Summary of Submissions - Community Submissions - MP09-0039 - 157 Redfern Street, Redfern

Proposed - 21 June 0900
Scale 1:2000

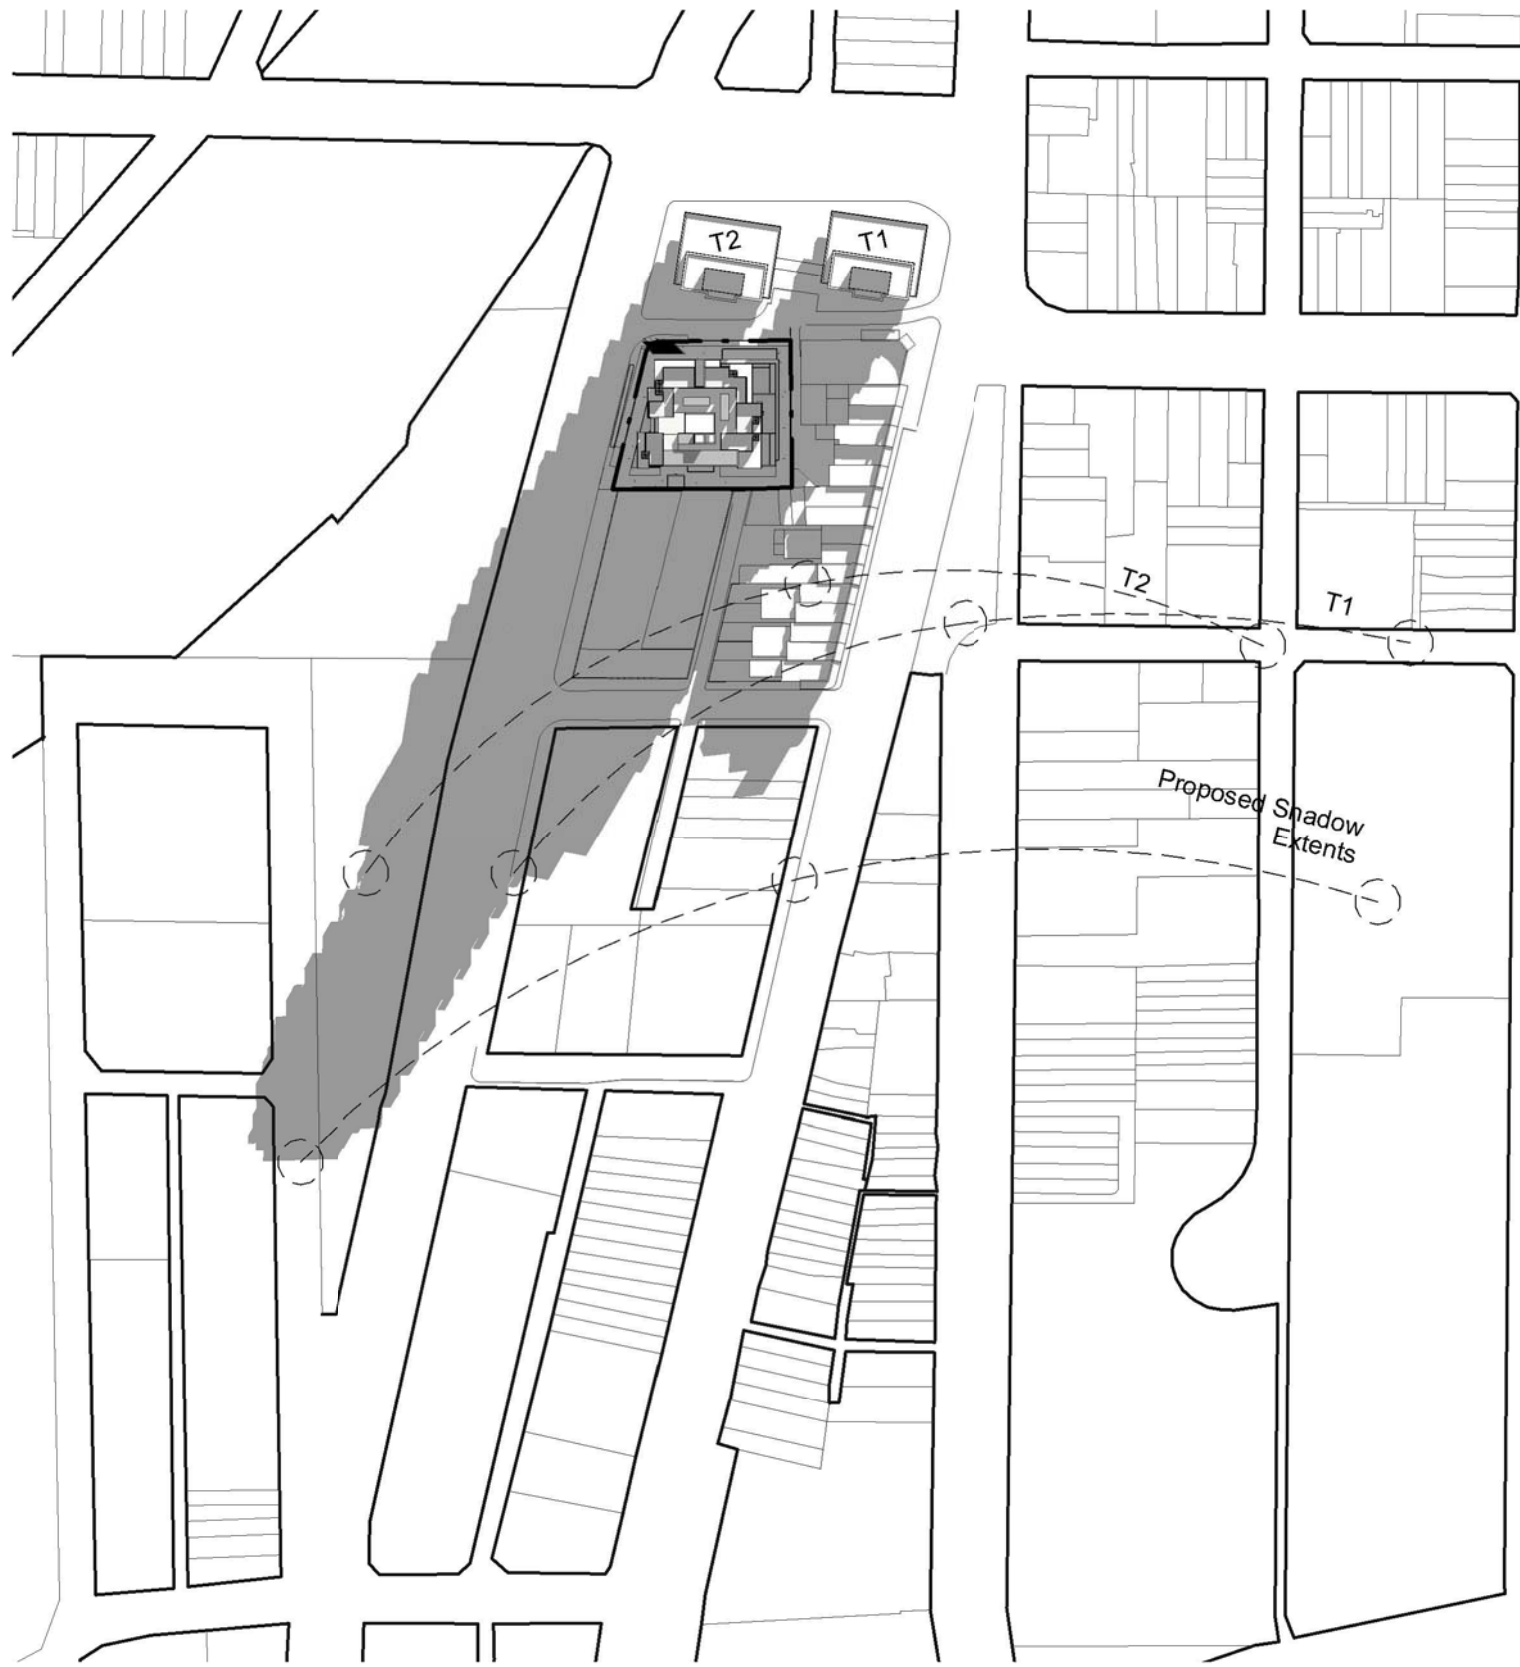
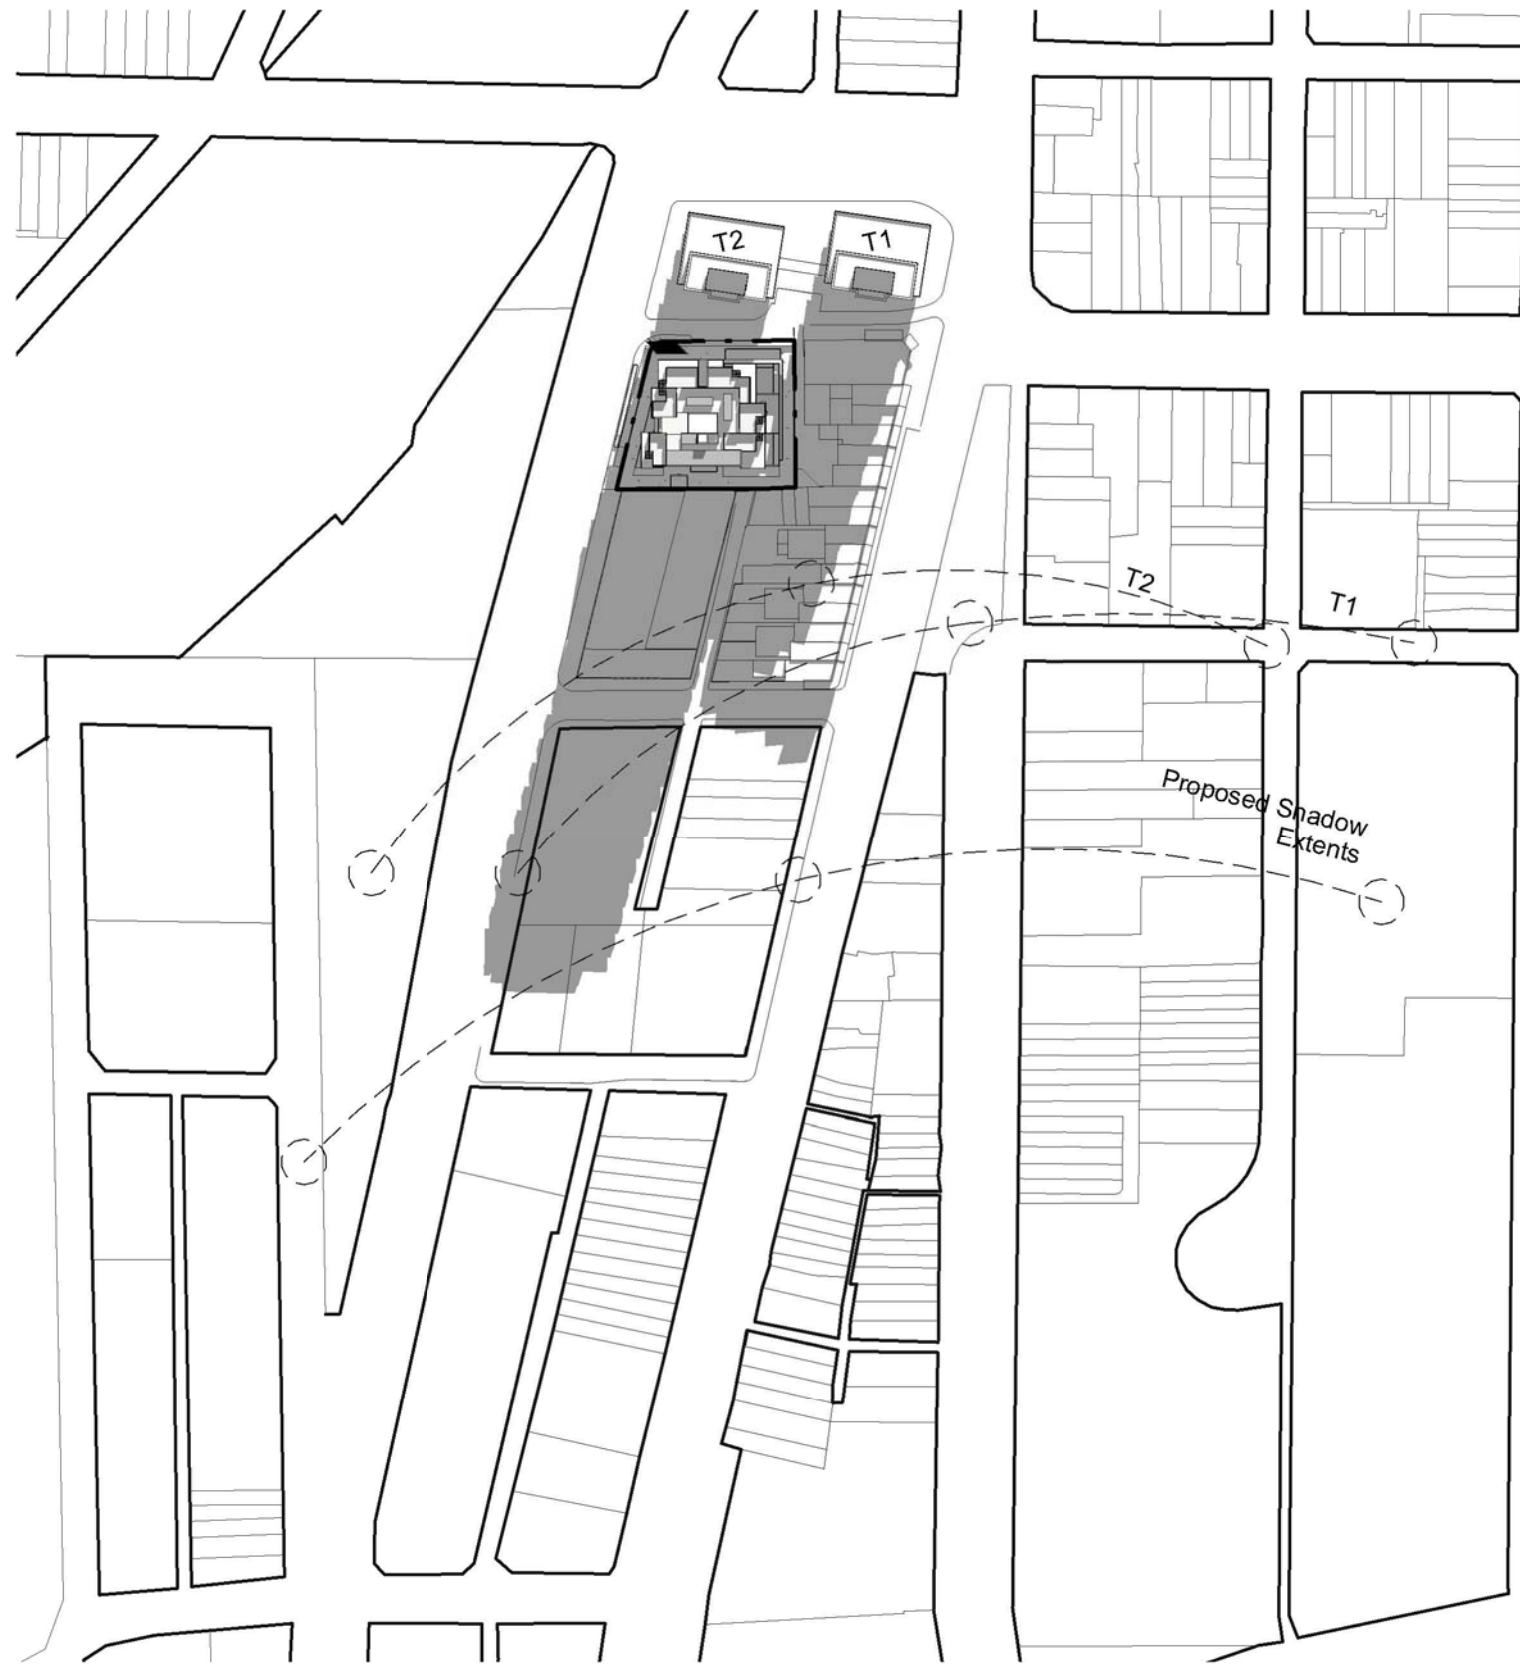
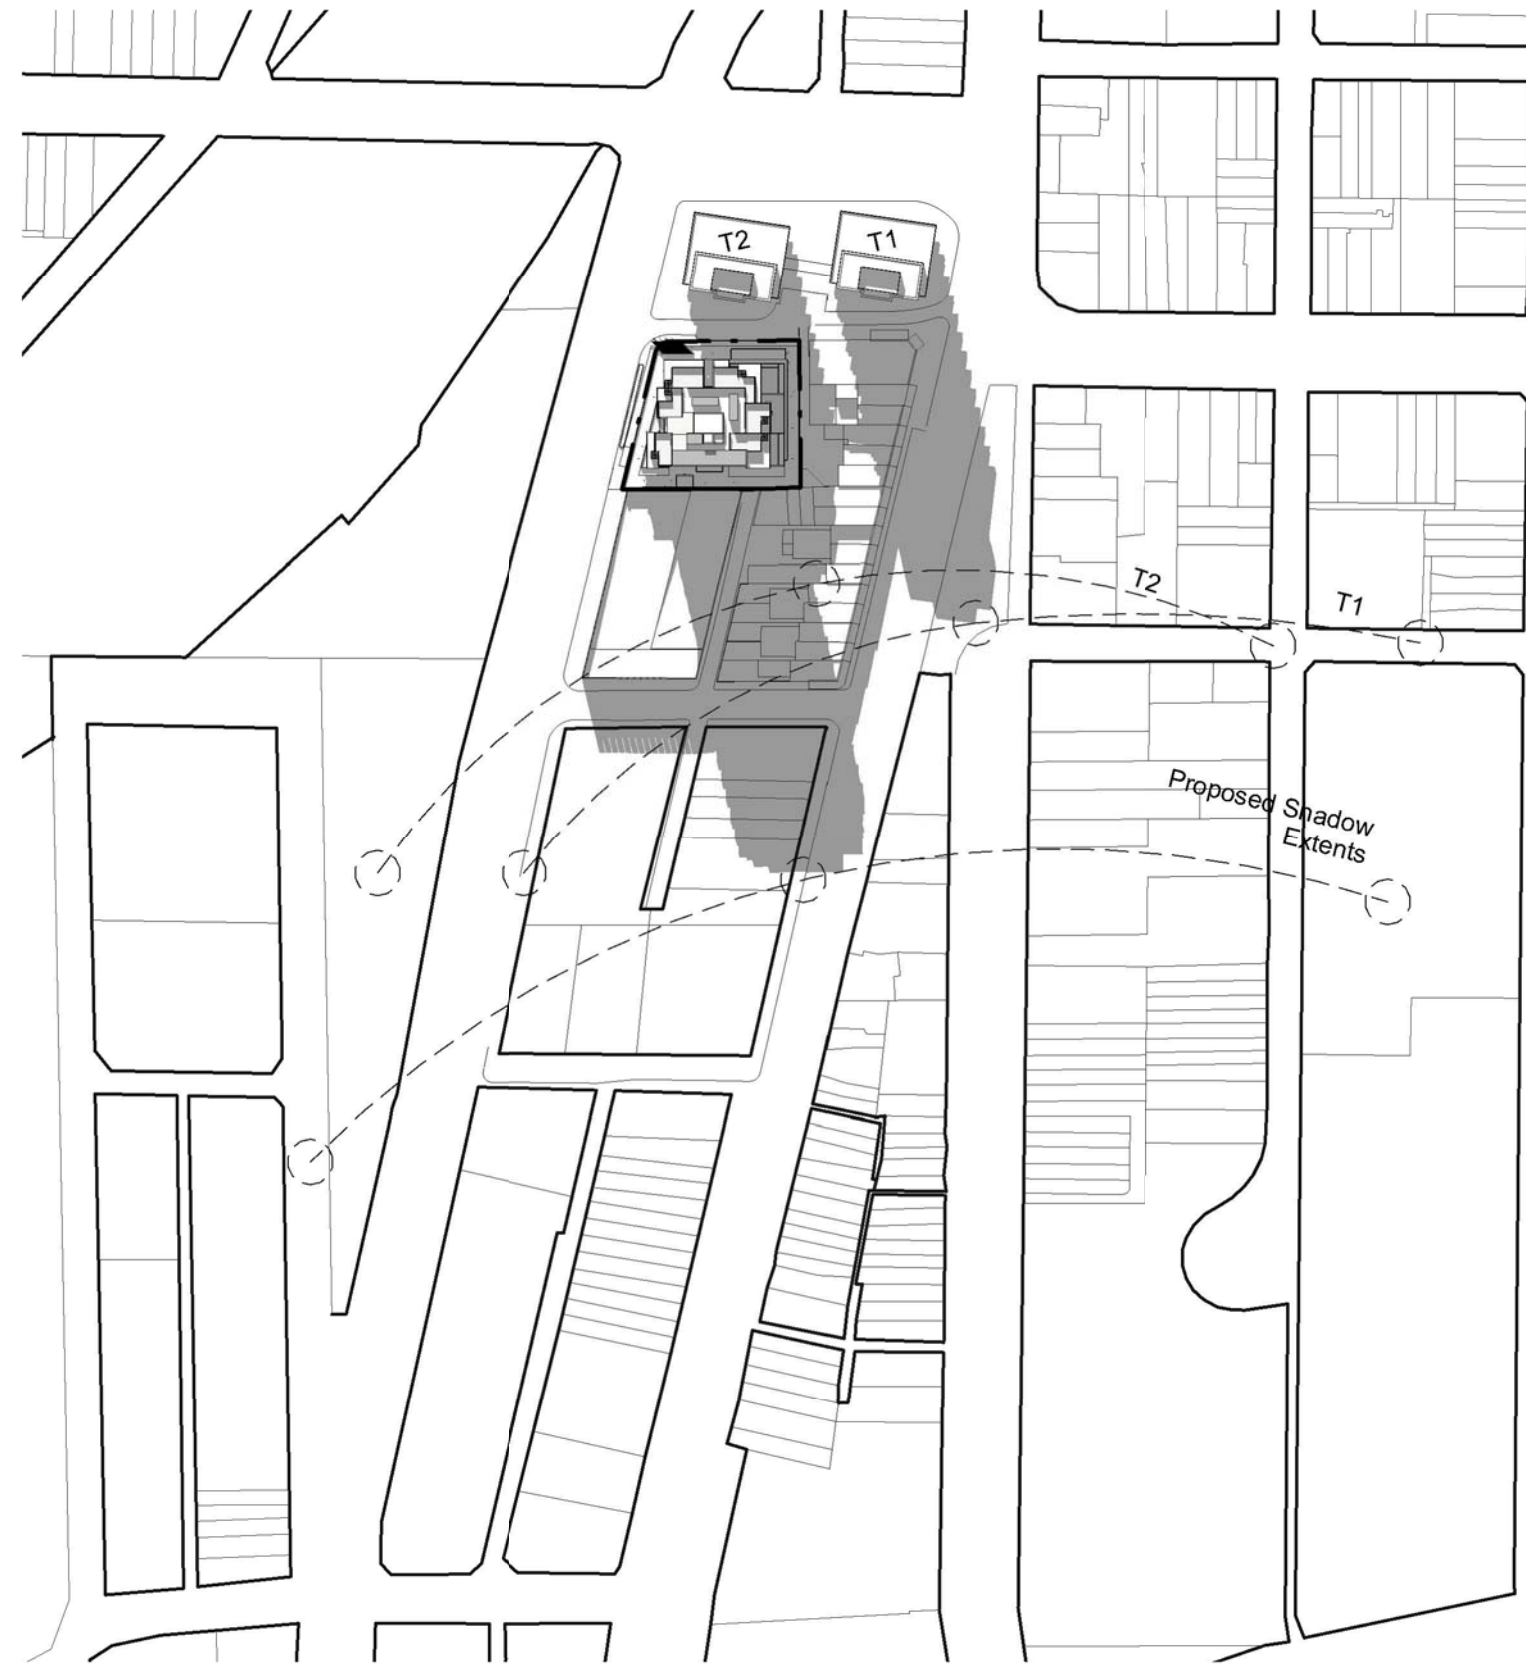
Submittor	Submissions	Response
Kevin O'Sullivan 32/13 Margaret St, Redfern	Objects on the basis: - the height of the building and it being out of character with surrounding development; and - the overshadowing of surrounding development, including 13 Margaret Street	See Sections 3.1.1 and 3.1.12 in Preferred Project Report. Solar access diagrams were submitted with the application. The proposal will marginally overshadow 13 Margaret Street between 9.30am and 10.30am at the winter solstice. This overshadowing will be subsumed by shadows cast by existing and proposed building between the site and 13 Margaret Street.
Scott Goddard 39b Turner St, Redfern	Objects on the basis: - the height of the building; - the overshadowing of surrounding development; and - wind tunnel effects	See Sections 3.1.1, 3.1.9 and 3.1.12 in Preferred Project Report. Solar access diagrams were submitted with the application.

Liza-Mare Syron 24/17 Cope St, Redfern	Objects on the basis: - the height of the building; and - the overshadowing of surrounding development	See Sections 3.1.1 and 3.1.12 in Preferred Project Report. Solar access diagrams were submitted with the application.
Matthew Kennedy 24/13 Margaret St, Redfern	Objects on the basis: - the height of the building; - the overshadowing of balcony and bedroom windows; and - loss of property value	See Sections 3.1.1 and 3.1.12 in Preferred Project Report. Solar access diagrams were submitted with the application. The proposal will marginally overshadow 13 Margaret Street between 9.30am and 10.30am at the winter solstice. This overshadowing will be subsumed by shadows cast by existing and proposed building between the site and 13 Margaret Street.
